**Bersted
Parish Council**

Please find enclosed a letter of
objection, regarding planning Application
BE/151/11, received by us.

Planning application BE/151/11

SHRIPNEY GARDEN CARAVAN PARK, SHRIPNEY LANE, SHRIPNEY
Proposals 01
Nov 2011

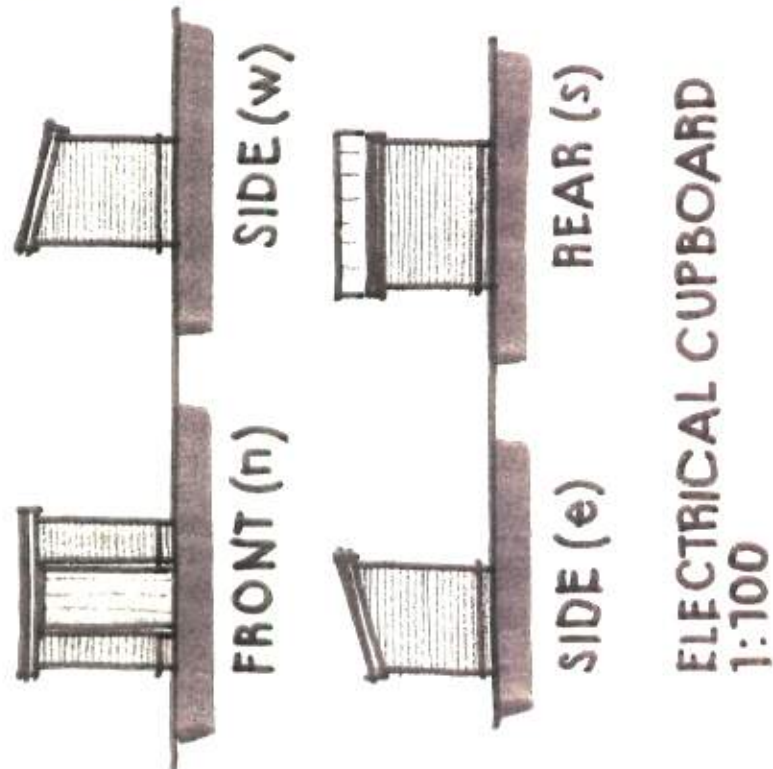
3. PDAS section 1.03 is totally untrue. The new application shows the bases to be significantly (approximately 4 metres) closer to the conservation area than the original.

4. PDAS section 1.04 – 1.06. The report suggests the new siting of the caravan pads on the northern side of the site was to accommodate the car park and the two trees. The report fails to recognise that a number of trees have previously been felled on the site, and that by simply moving the last two caravans around 4m eastwards (rather than moving it to the southside and then 14m eastwards) both trees would have been protected anyway.

I do not accept that the access needs to be on the southernmost part of the site. The road would be perfectly wide enough where the original access was designed – which is wider than most of the rest of the road. In fact the road must be wide enough to accept and allow access to caravans as the site owner knows full well – since he owns the caravan site to the north, along the road where the application now says the road is too narrow. Nor do I accept that the internal layout of the tarmac required amendments. Caravans (which are very rarely moved) could have been placed on the pads perfectly easily using the original road layout. 'Ease of access of delivery of caravans' should not have been a key design element when it is plain that a) the original access was adequate and b) the access was being moved closer to neighbours.

5. The statement by Henry Adams in 2.01 that the site is as the approved plan apart from the eastern boundary being approximately 12m eastwards beggars belief.

- **Not one** of the caravan pads is in the same position as the original plan
- The eastward boundary has moved 30m not 12m as the applicant has laid a tarmac road some 20m beyond the last caravan
- The access has moved significantly closer to the conservation area
- The site now doesn't appear to include a section in the north of the site – which has been used to move a caravan from the original caravan park
- The car park has changed – although perhaps not significantly
- There is one access road not two
- There is a new brick structure housing electrical intake

1. Places caravans significantly closer to the residential development and conservation area
2. Extends the site and places additional caravans in an area that is not screened from its neighbours

3. Places an entrance closer to residential properties where cars will stop with their engines on at all times of the night to open and close gates
4. Places an electricity station inappropriately immediately next to a residence

5. Includes an extra 30m of tarmac road over agricultural land, for which there is no reason or need. The land is protected under PPG7
6. Has been planted with Leylandii which cannot in anyway be seen to be protecting the sensitive location adjacent to a conservation area. The original application was agreed with a mixed hedgerow with traditional native species.
